From: Rhiannon Lloyd
Sent: 19 August 2026 11:03
To: Planning.Responses
Subject: Fw: R/86/26/PL - 15 Churchill Parade - SUB PLAN
Attachments: 101047.101_C.pdf

Please upload the attached sub plan for R/86/26/PL. This should be REV C.

Subject: R/86/26/PL - 15 Churchill Parade

PROPOSED FRONT (SOUTH) ELEVATION
Scale 1:100

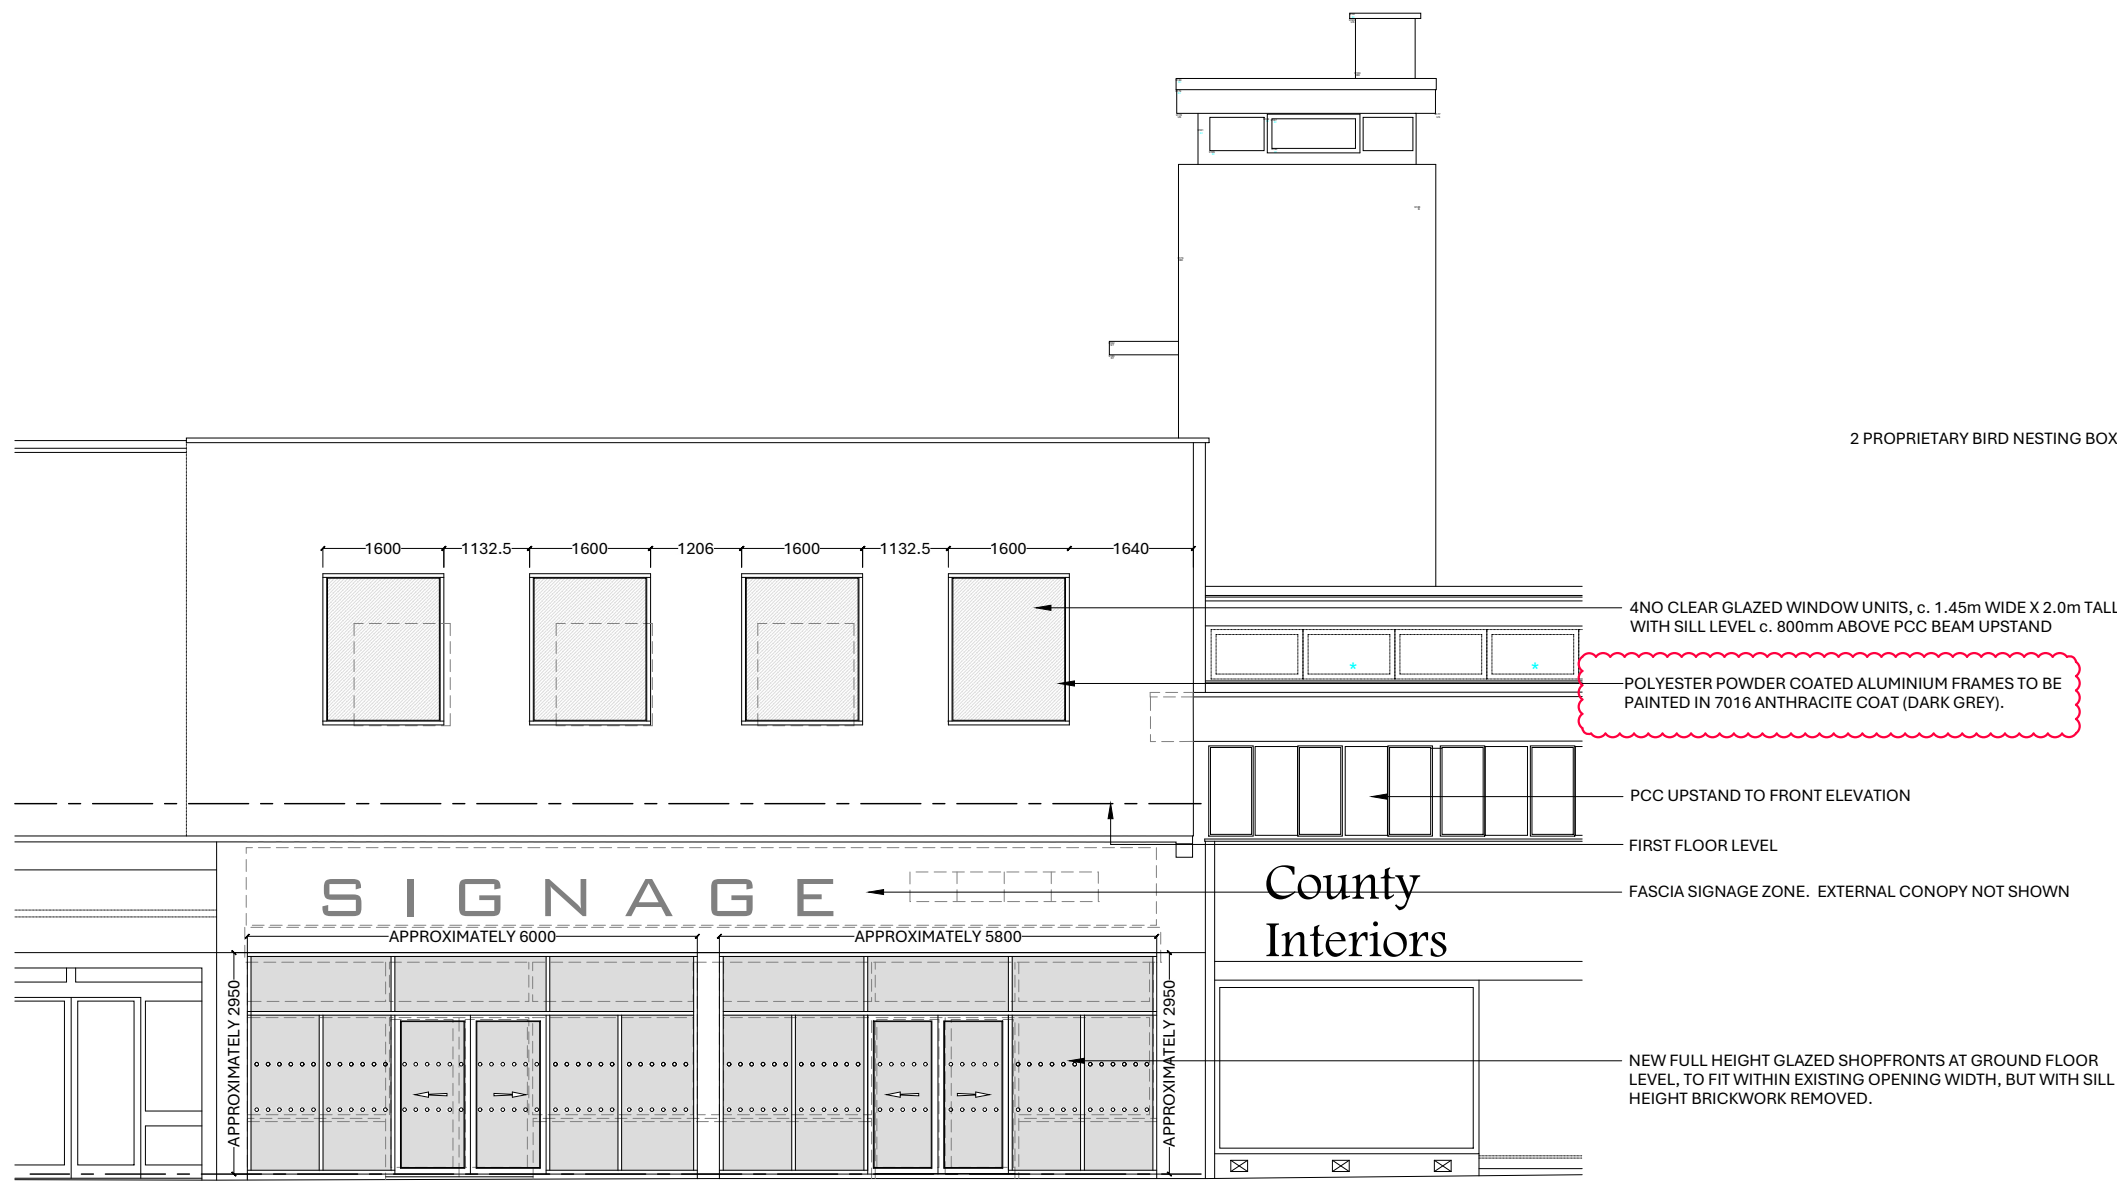
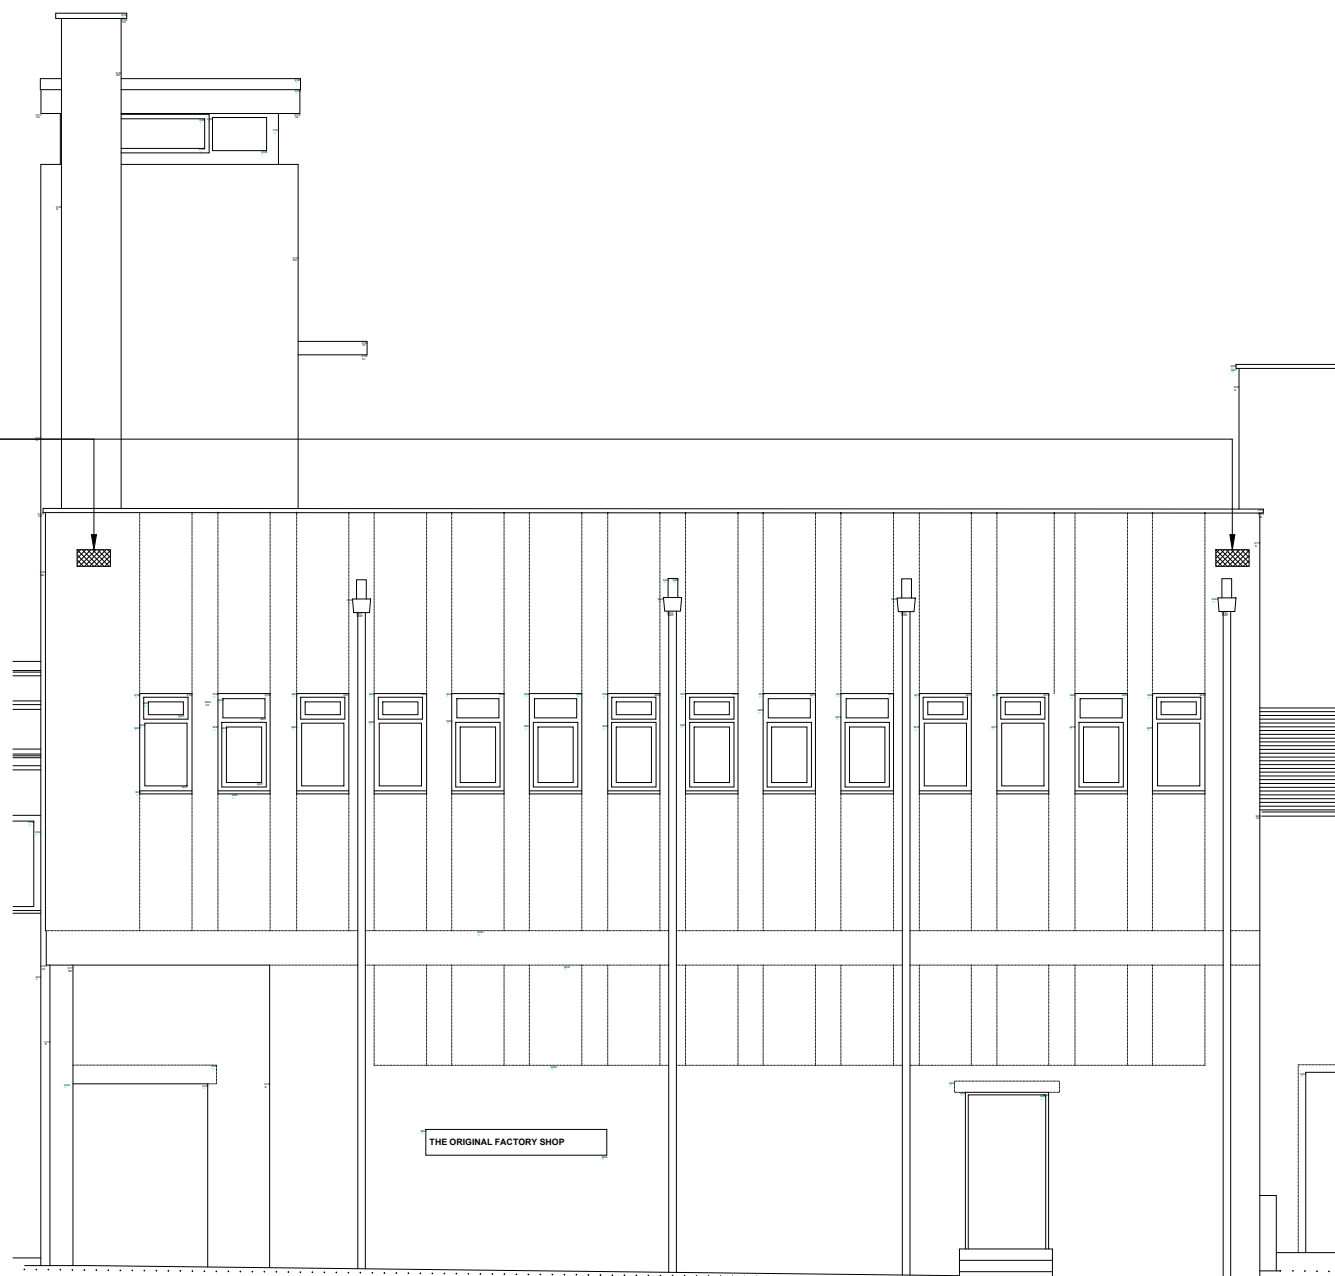
I write to you to query the proposed materials for the frames of the shop front alterations and the first-floor windows to be installed. The application form indicates powder coated aluminium frames, but I am unclear that this is reflected on the plans. I am also not clear on the colouration. The shopfront has a fair bit of flexibility with colour, however, clarification regarding the colour of the frames at first floor would be appreciated. I would also advise that if the client is confident in the materials and colours they will be selecting, confirmation of this may be an opportunity to avoid the need for any materials discharge condition to be attached to any grant of permission.

I have received confirmation that the planners wish to use RAL 7016 Anthracite Grey for the first-floor window frames.

I have also added these notes to the proposed elevation drawings, (please find attached).
